## **The Examining Authority's (ExA's) first written questions and requests**

The following table sets out the Examining Authority's (ExA's) initial written questions and requests in relation to the proposed Yorkshire and Humber CCS Cross Country Pipeline. Responses are required by **Thursday 18 December 2014**. Please note that if this deadline is missed the ExA is not obliged to take account of your response.

DRG No 10-2574-PLN-01-0346

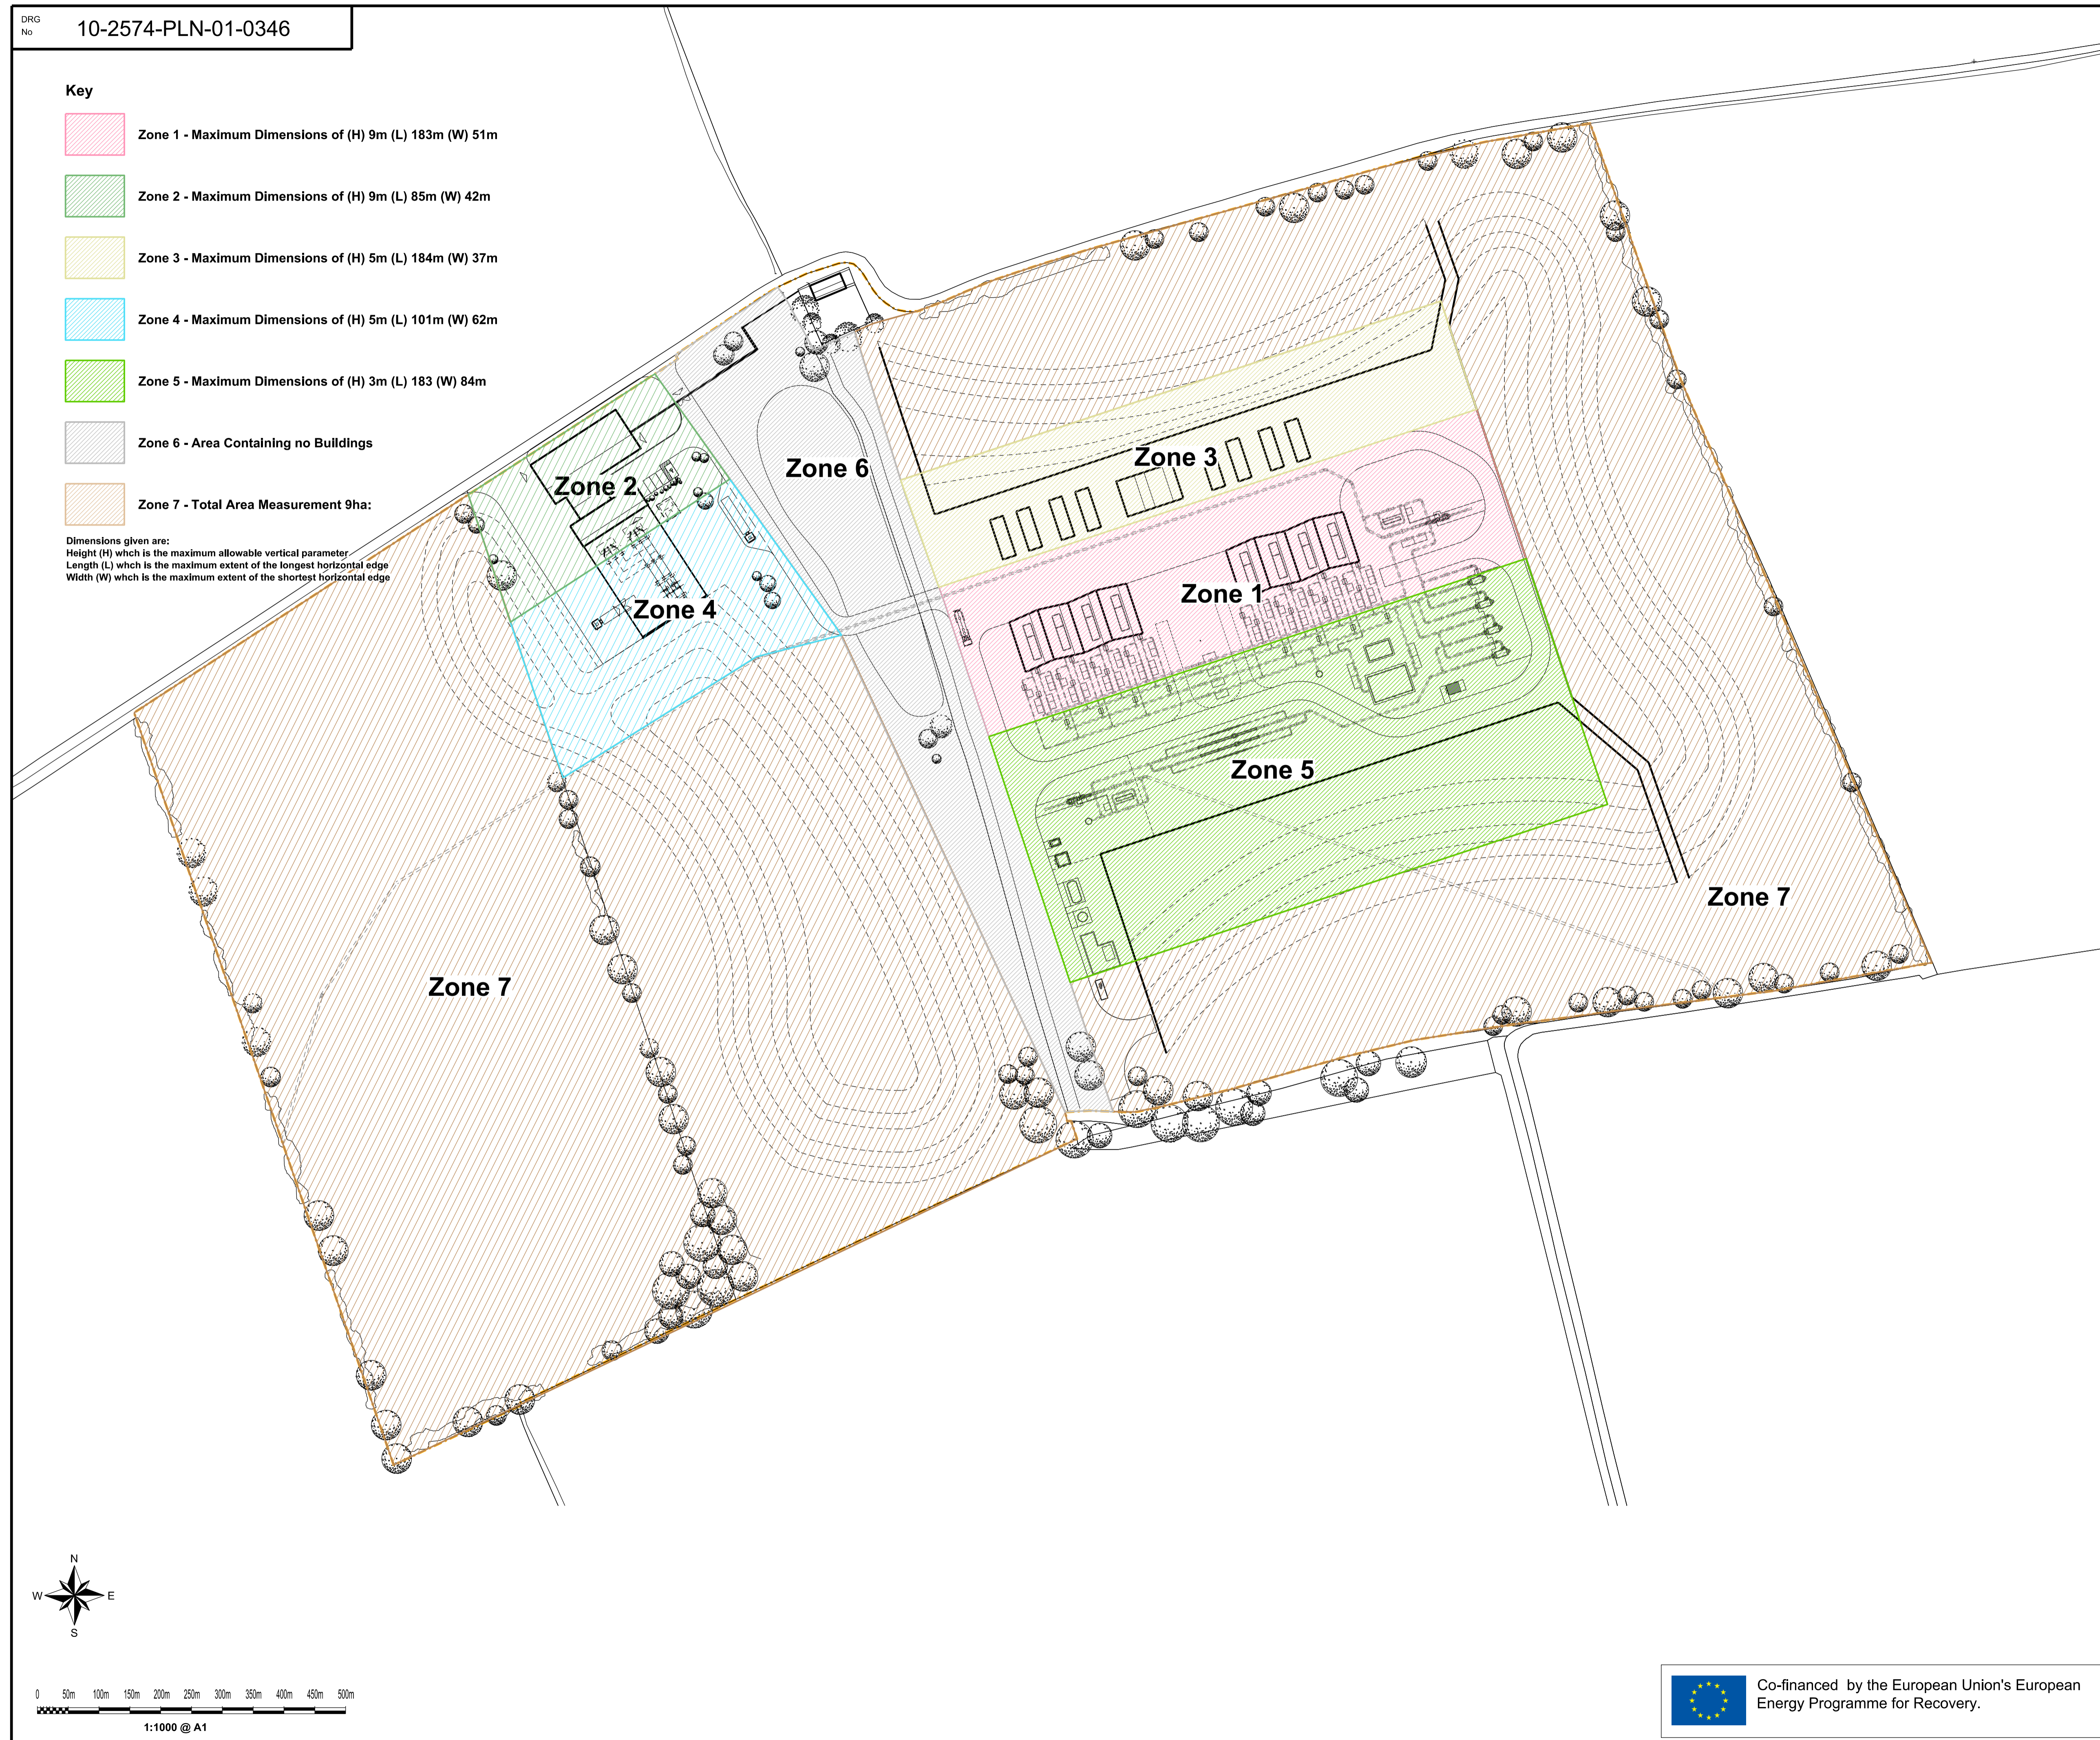
Q4.3	Applicant	Can the applicant clarify whether the Pumping Station vent stack would be 8m above ground level, if not, how high and how would this fit in with the heights of buildings and plant within the various zones (ES Chapter 3 para 4.6.20)?
Q4.4	Applicant	Can the applicant explain when, where and why the external lighting would operate at the pumping station (ES Chapter 3 para 4.6.29)?
	<b>AGIs:</b>	
Q4.5	Applicant	Can the applicant explain how the access and egress lighting would work at the AGIs (other than the pumping station) if the operational lighting would not be permanent?
Q4.6	Applicant	Can the applicant explain how the planting schedules at the AGIs are secured in the DCO with schemes for implementation, timing and enforceability?

SHEET	1	OF	1	SCALE	1 : 200 @ A1	A1	
DRG No	10-2574-GA-01-0306					ISSUE	A

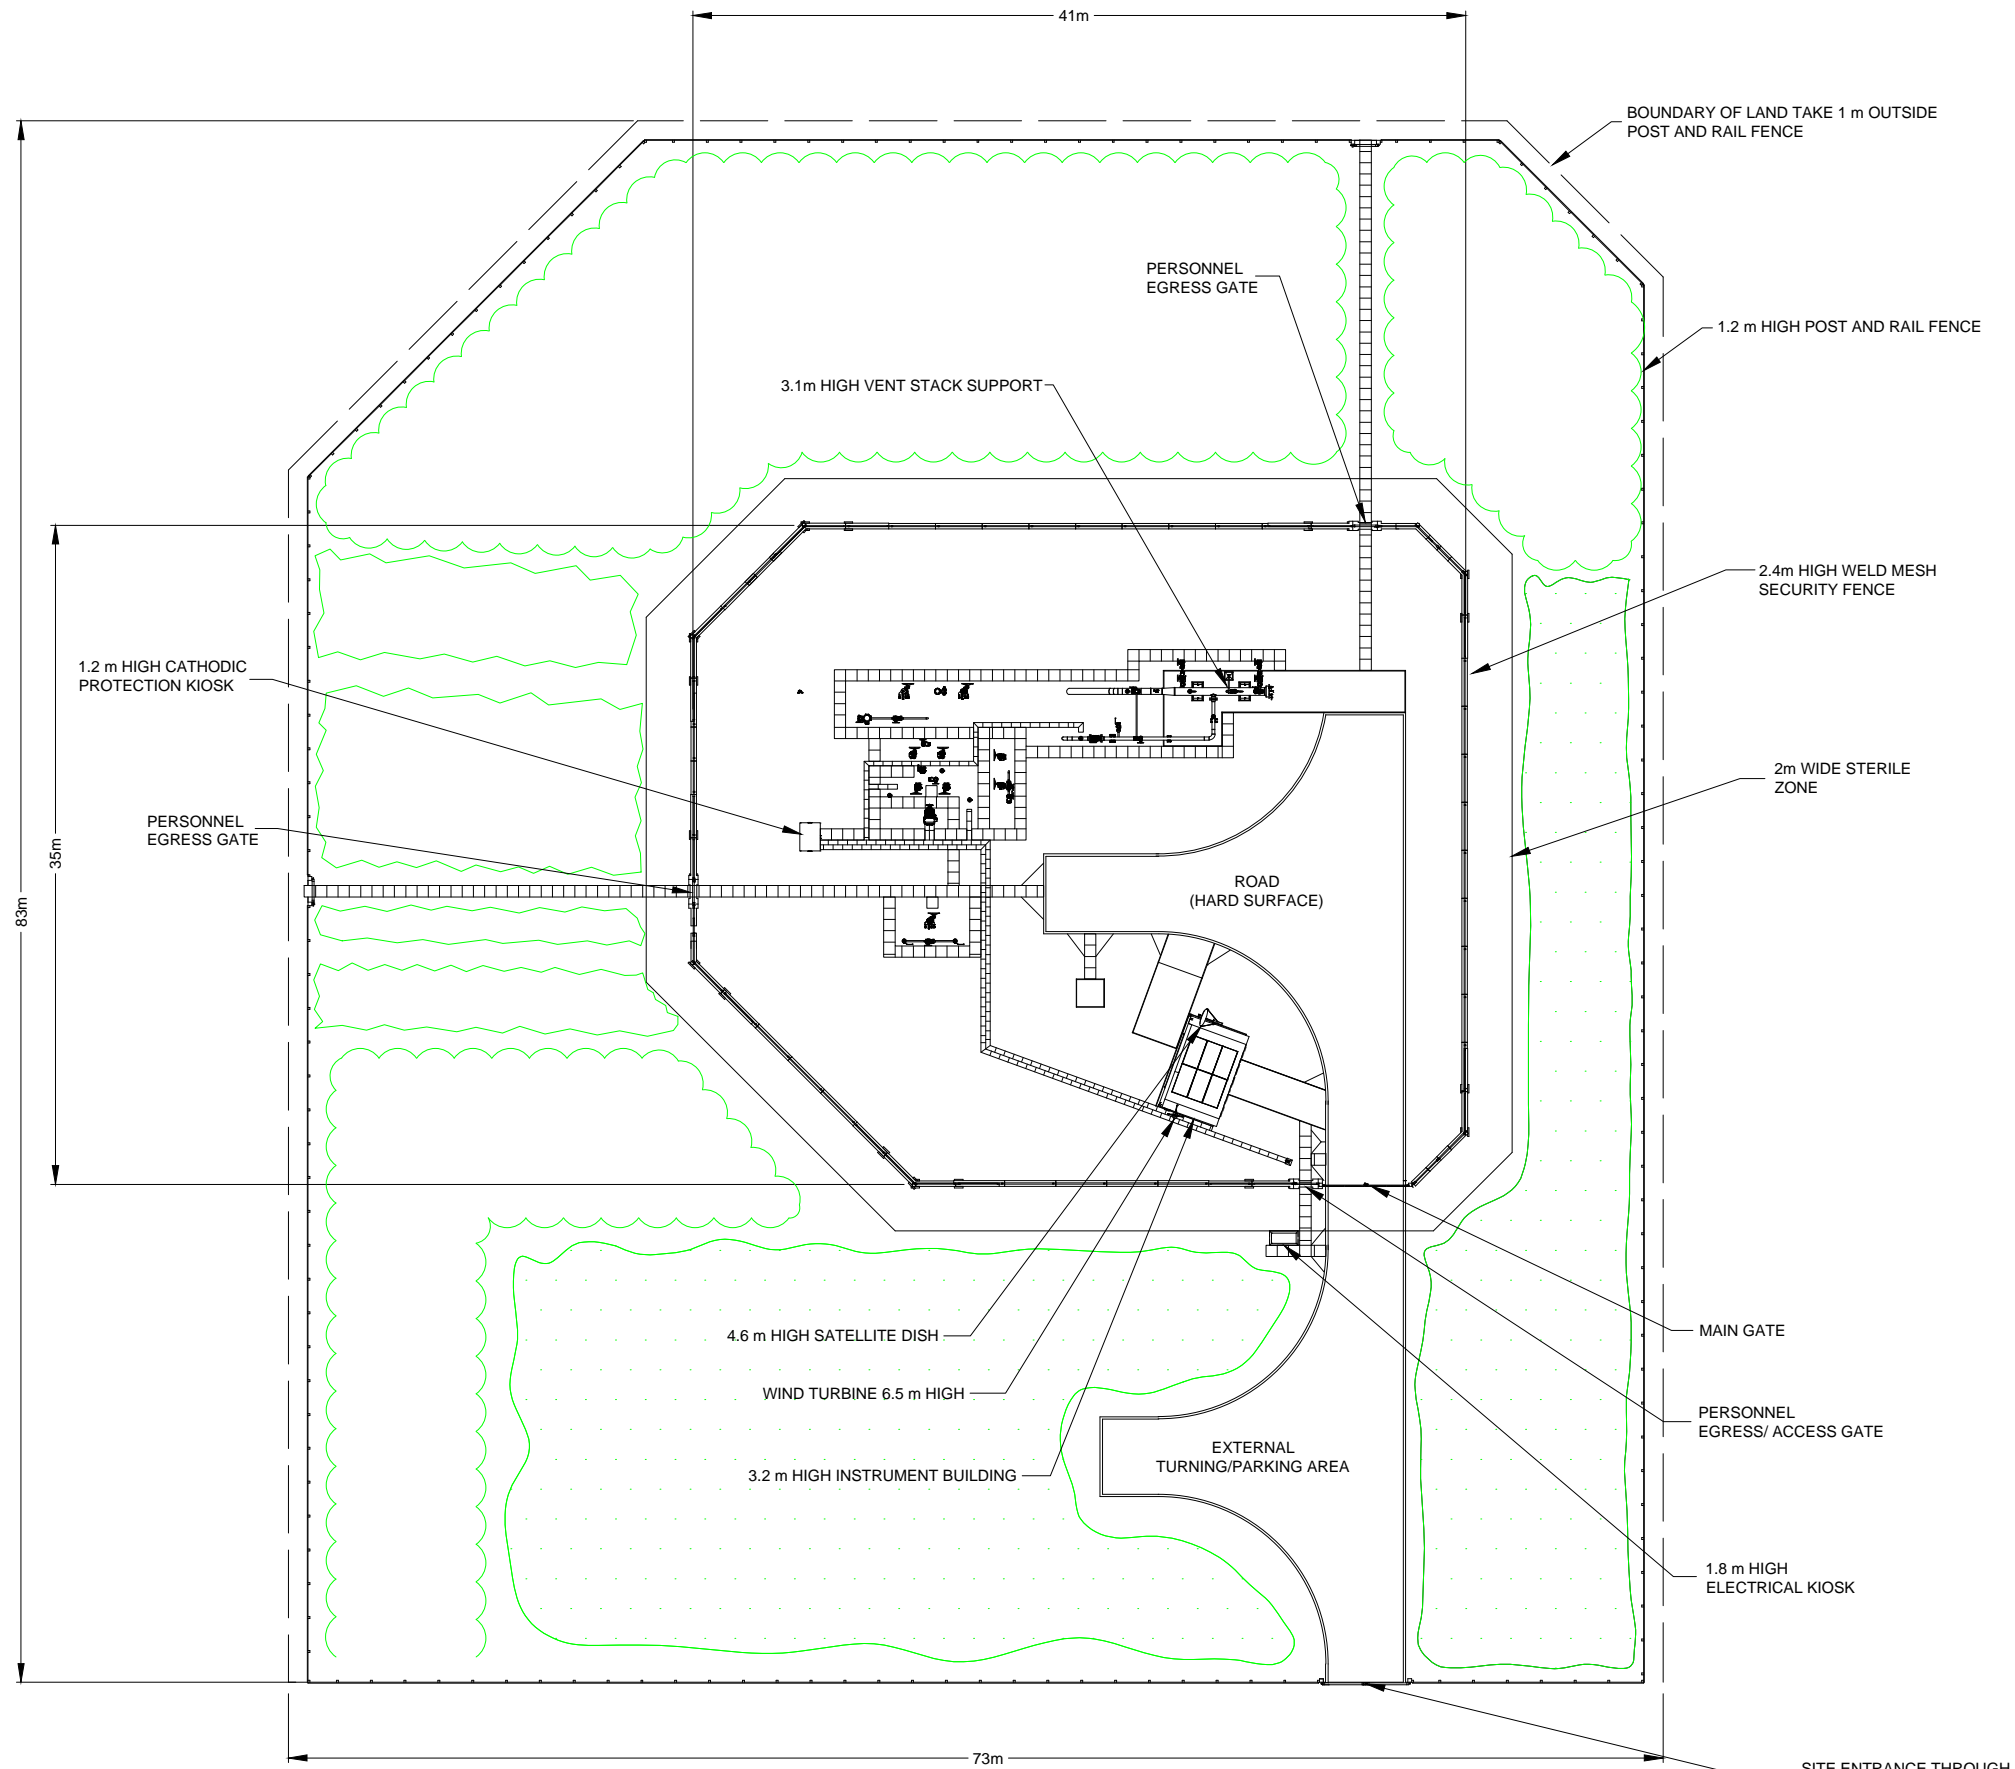
<b>Q1.4</b>	Applicant	Can the applicant explain how the elevations of the Drax PIG trap and the Camblesforth Multi Junction by 1m above ground level (and 0.3m at the Skerne Block Valve) is sufficient to mitigate against potential flood risk (ES Chapter 3 para 4.1.23)?
<b>Q1.5</b>	Applicant	Can the applicant explain how many employees would work at the Pumping Station 24/7 both during construction and upon completion?
<b>Q1.6</b>	Applicant	Can the applicant explain the construction sequence and timing as a development of the table at 7.5 (para 1.5.1). For example, would the pipeline be built in sections between or either side of the block valves and what would be the approximate speed of construction within a section? Would the sections be self contained and is there an intended sequence of sections within one season - April to September?
<b>Q1.7</b>	Applicant	The construction of the pipeline would commence in 2018 and is anticipated to take one season (beginning in April to the end of September) (ES Chapter 3 paragraph 5.2.29). This construction period has been assumed throughout the ES. Can the applicant describe what assurances there are that
